Application No: Y/3/22/OUT
Site Address: Land West of Bilsham Road Yapton
Description of works: Hybrid Application comprising of Full application for Phase 1 for 30 No residential dwellings, new access from Bilsham Road, public open space, landscaping, sustainable urban drainage and associated works; and Outline planning application for further phases of up to 110 No dwellings and associated infrastructure (with all matters reserved). This application is a Departure from the Development Plan and is in CIL Zone 3 and is CIL Liable as new dwellings.

Thank you for your internet representation made on 3rd February 2022 which has been recorded as an objection with the comments as follows:

Client	LANDLINK ESTATES
Project	LAND WEST OF BILSHAM ROAD, YAPTON
Title	MAISONNETTES - BINS & CYCLE STORE

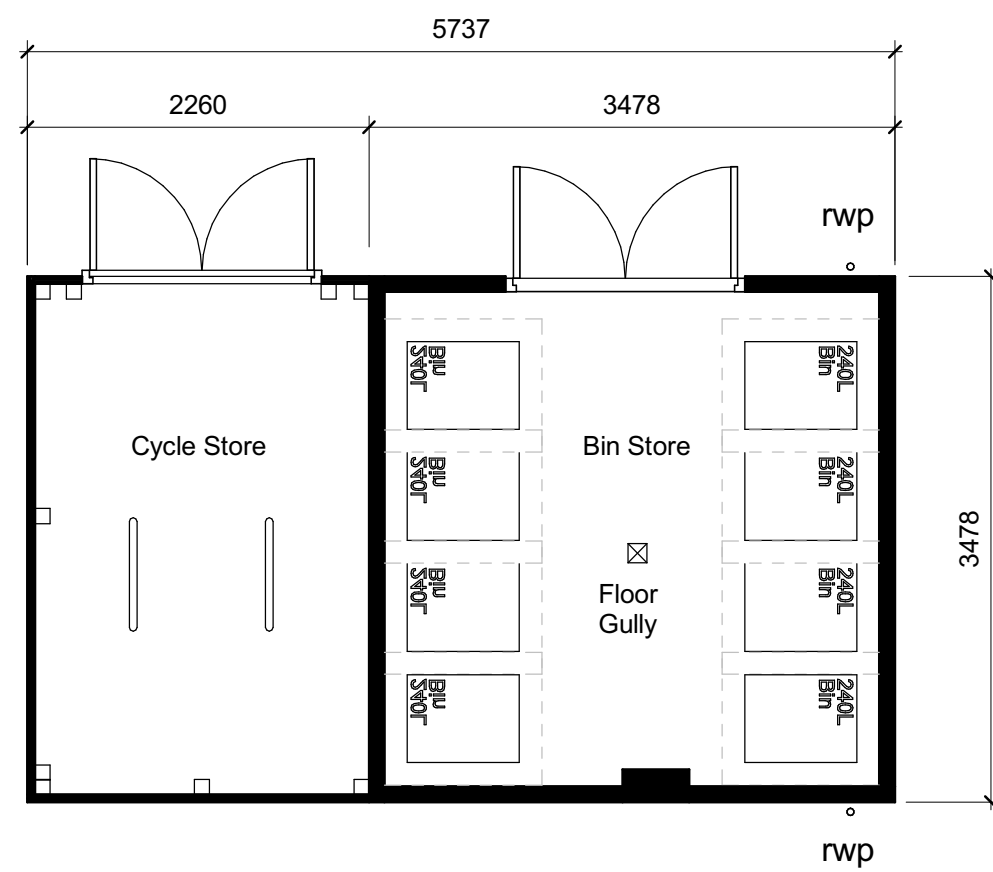
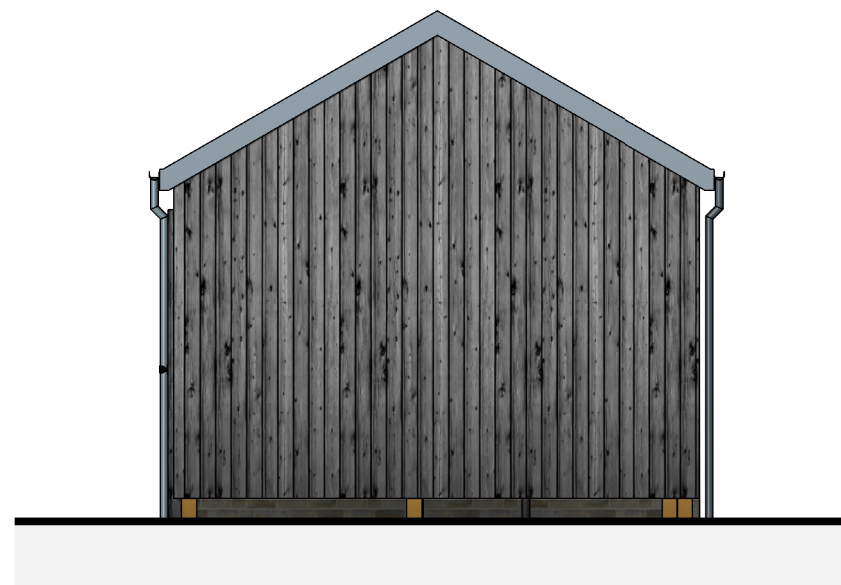
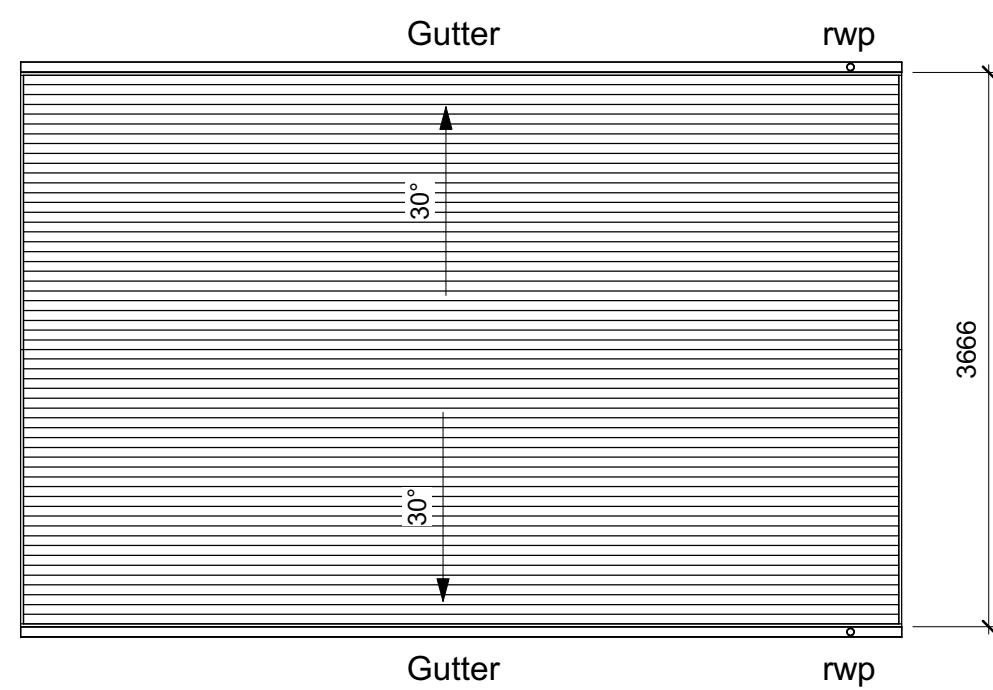
The design is not in keeping along Bilsham road with 2 blocks of flats 10-13 14-17 with balconies overlooking the cottages opposite encroaching on privacy. The street is houses all along so this development should have been designed to be in keeping with that.
